Recommendation Report for Planning Permission for Works or Extension to a Dwelling

REF NO: AW/90/21/HH

LOCATION: 10 Gunwin Court
Aldwick
PO21 4BW

PROPOSAL: New pitched roof to garage.

Proposed Southeast (front)

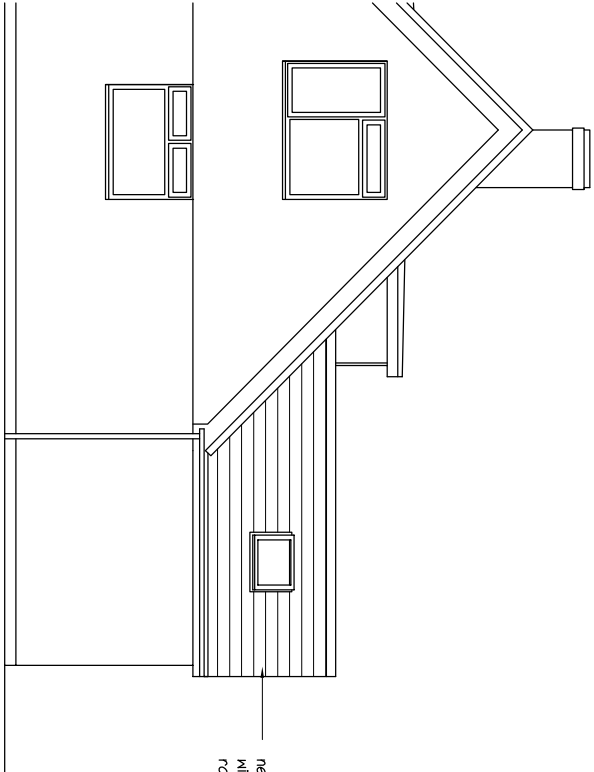
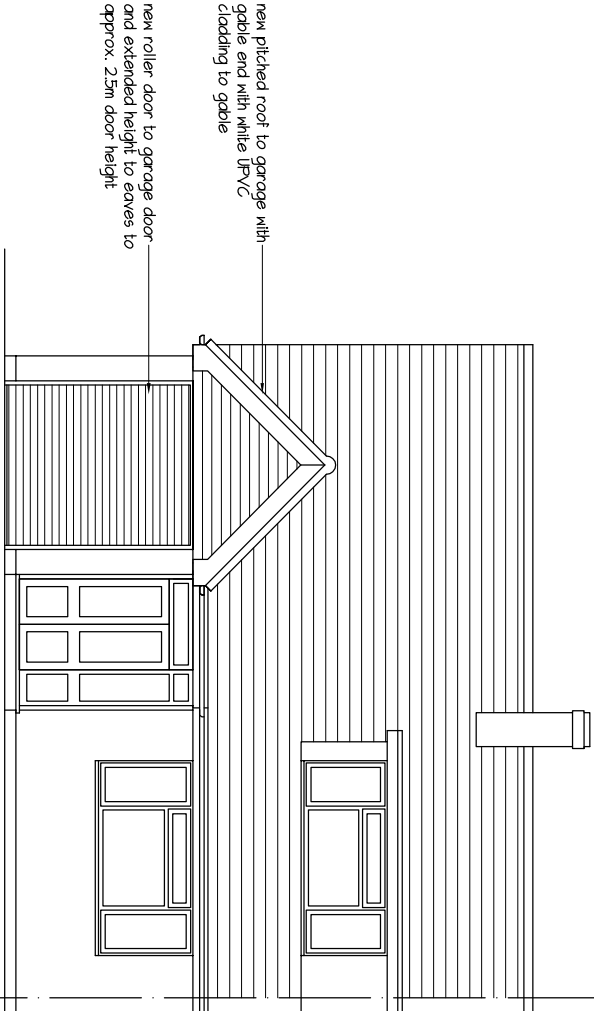
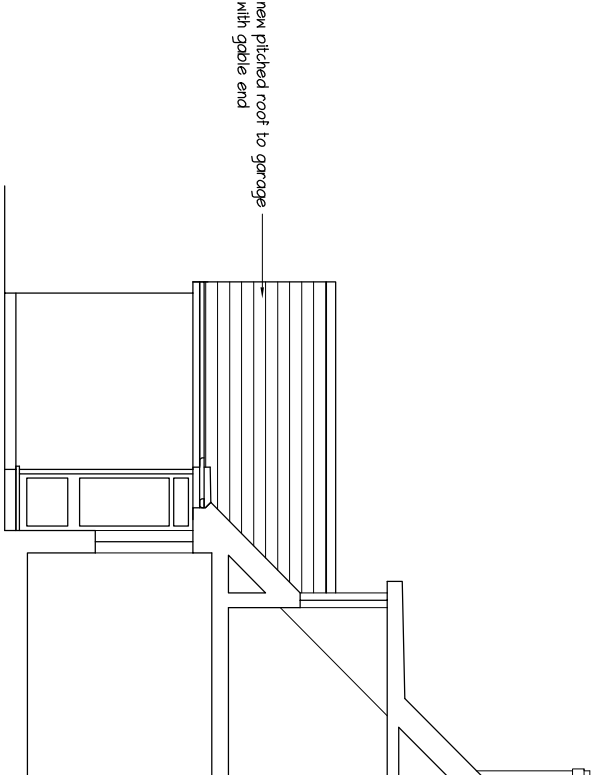
The proposal will be highly visible from the street scene. Whilst the design is not-in keeping with surrounding properties, the host dwelling does has a pitched roof so is in-keeping with existing property. Due to the scale and siting of the proposal it is not deemed to adversely affect the character of surrounding area so complies with D DM1 of the Arun Local Plan.

The proposal will be a pitched roof with a gable end. The width will be 3.32m and height to pitched roof ridge line to 4.28m. The roof will contain one velux roof window on south west side of proposal. There will also be new roller garage door and extended height to eaves to approximately 2.5m door height.

Arun recently adopted a Design Guide. It states that development should be subservient to the host dwelling. Whilst the proposal will be higher (approximately 4.28m to ridge line) than existing garage roof (2.68m to ridge line) it is still subservient to the main property so is deemed acceptable.

The proposed materials seem to match the existing property and will consist of UPVC cladding to new gable, interlocking concrete roof tiles, roller garage doors and no change to existing windows. The proposal materials integrate well with host dwelling so comply with D DM1 of the Arun Local Plan.

Proposed Roof

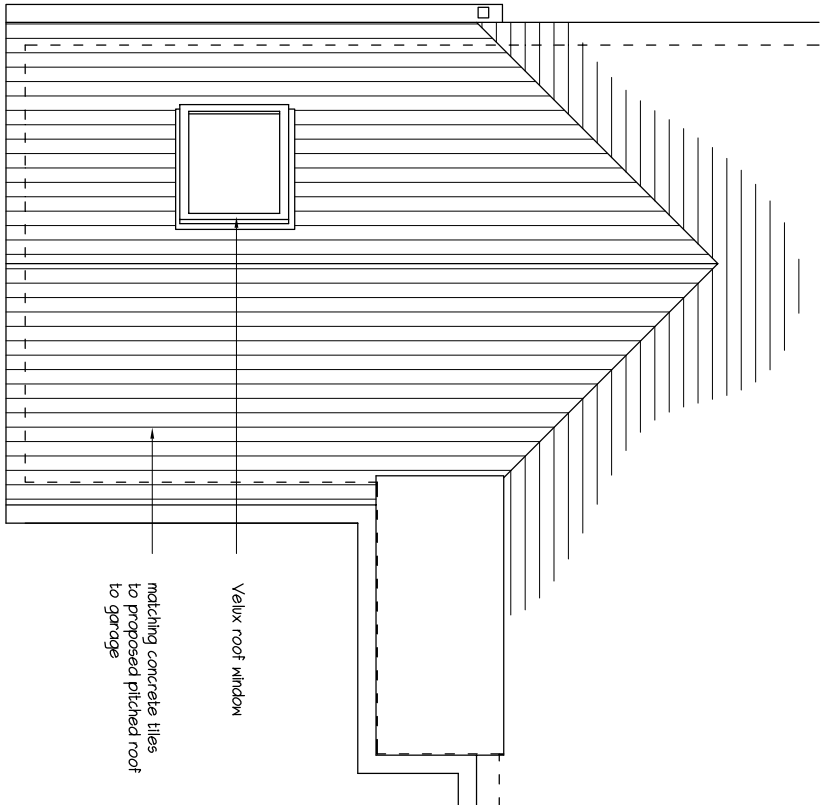
Whilst there is a new proposed roof window to south west elevation of garage roof, it is not deemed to increase harm to overlooking to neighbouring properties to south west due to the purpose of the roof light at high level.

Proposed Section

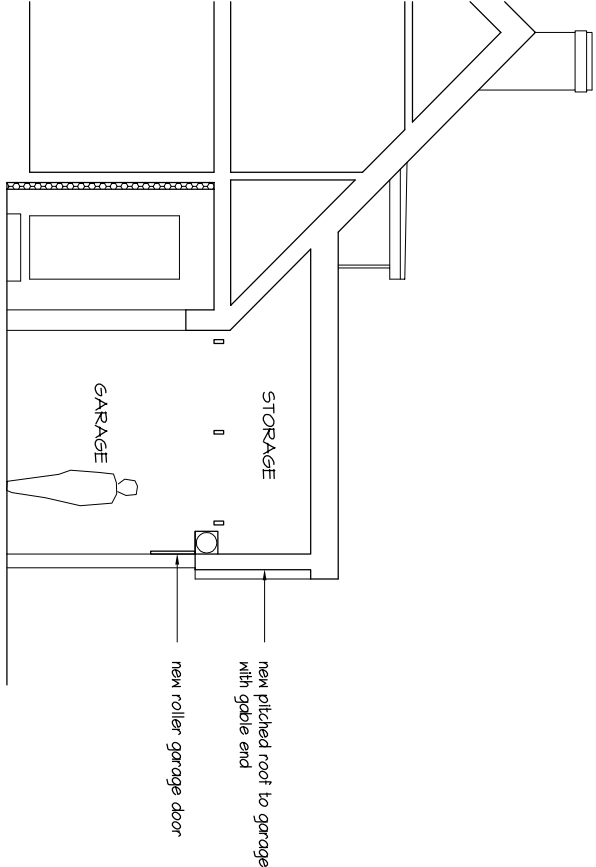
Due to the increased height of the proposal to 4.28m to ridge line, it will increase some overshadowing effect to front south east facing windows of neighbouring property number 8 however it is not deemed to cause adverse harm so complies with D DM4 of the Arun Local Plan. There will also be slight risk to overshadowing at neighbouring property to south west of site at number 12. However due to 1.39m remaining to south west boundary and building line at number 12 set back there is no adverse risk of overshadowing effect.
